RETAINING WALL DESIGN UPDATE

May 23, 2024

Re: 8243 West Mercer Way, Mercer Island, WA
Permit No: 1812-087

SHEET: **C-3**

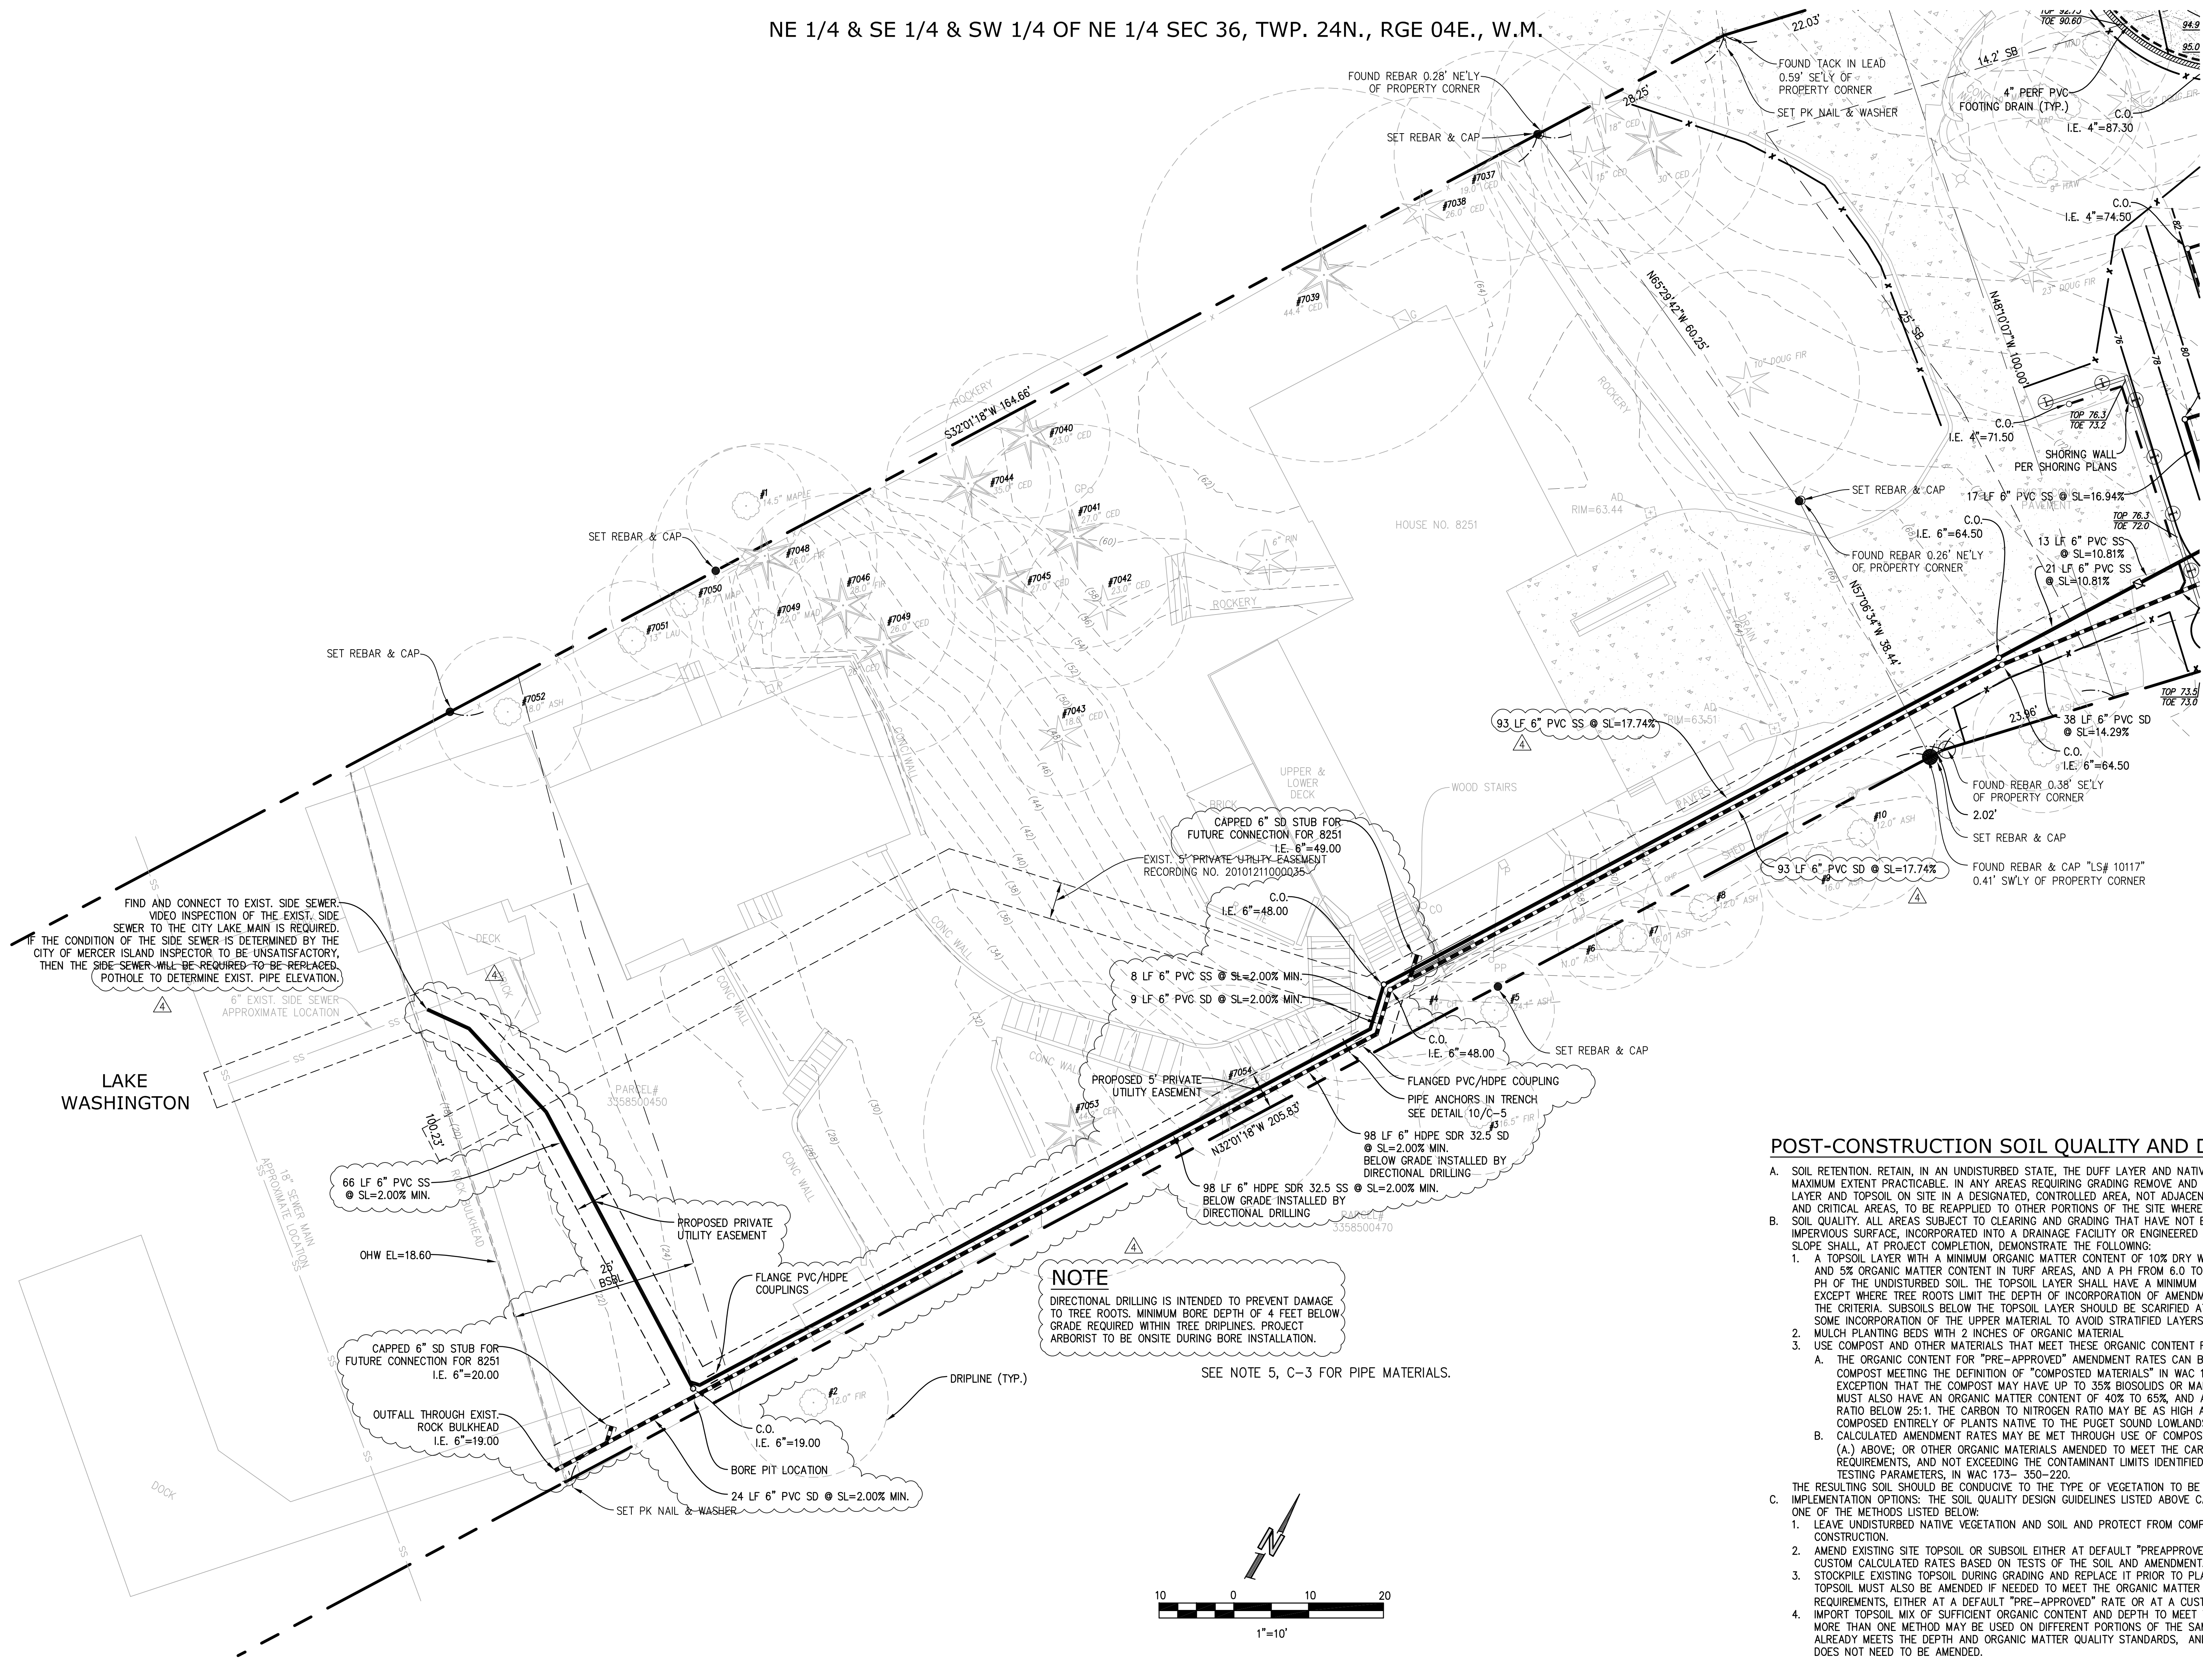
Originally, the retaining wall adjacent to the driveway has been illustrated in the drawing “C-3 Drainage Plan” prepared by Nick Bossoff Engineering, Inc. with elevation only but no detailed design provided, as shown below in Figure 1.

RETAINING WALL PLAN VIEW
AND DETAILS

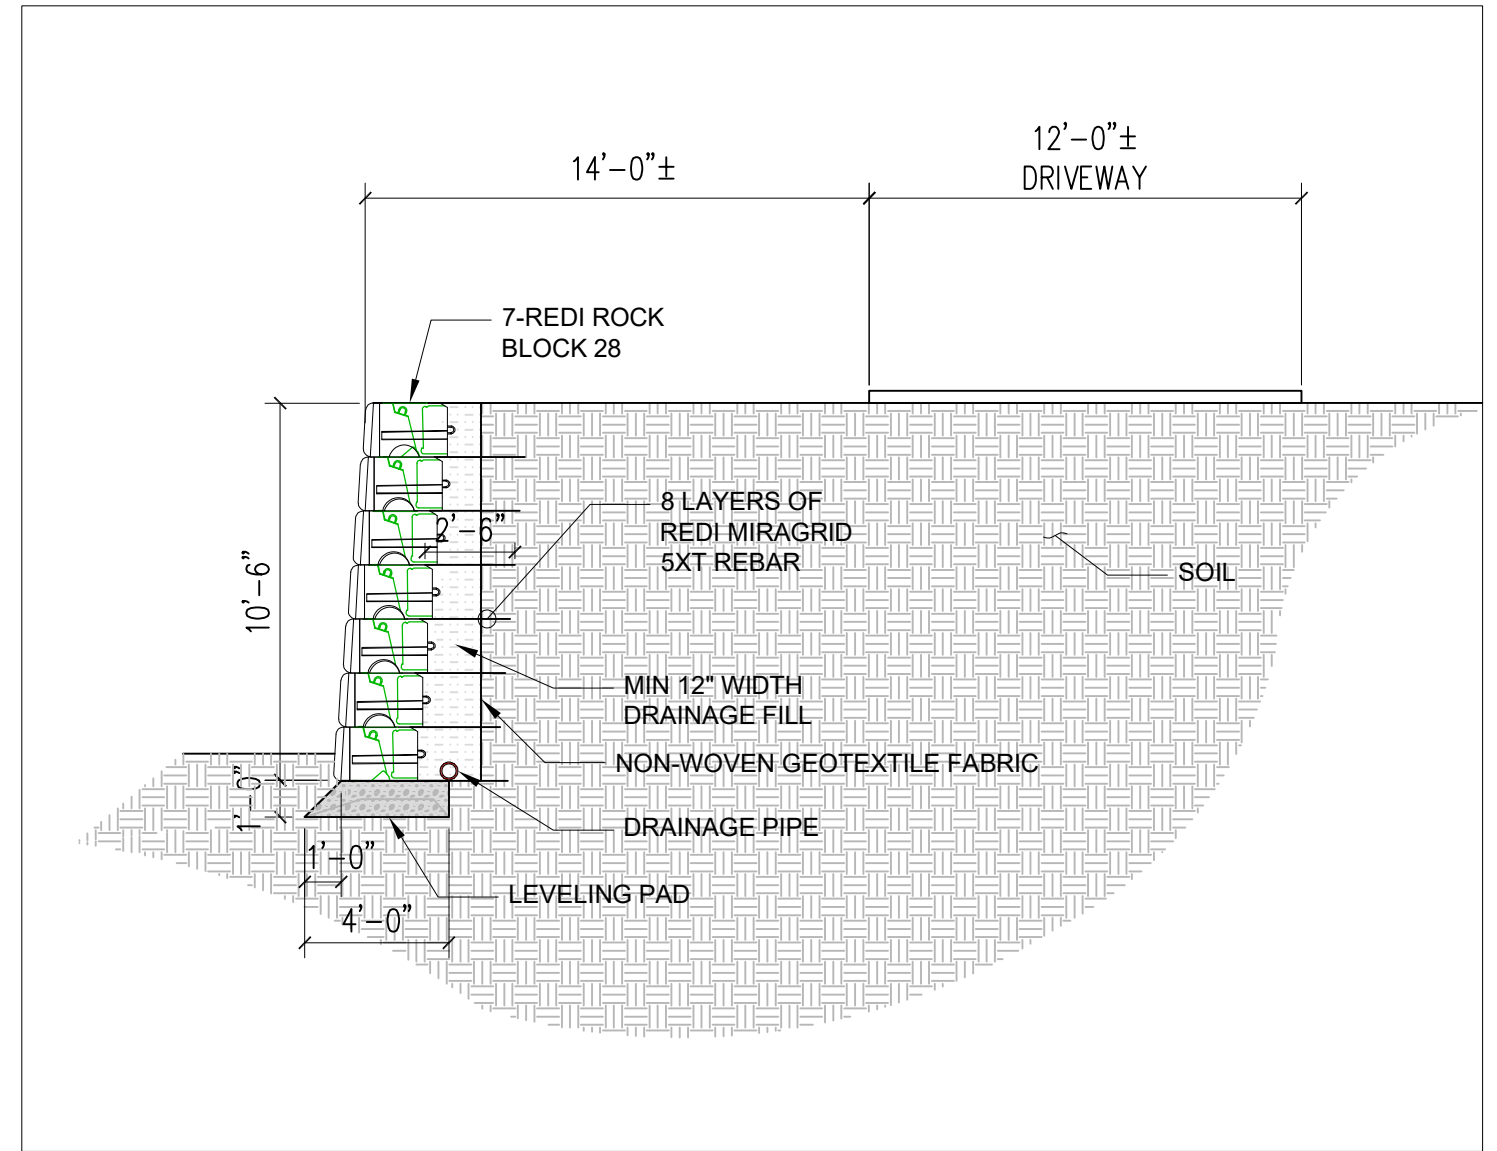
We provide a new design of 10ft ± high reinforced REDI-ROCK retaining wall with location shown in Figure 2, based on project geotechnical report No. 17-405 by PANGEO dated 02/08/2018, International Building Code (IBC), all reference codes, and all local by-laws.
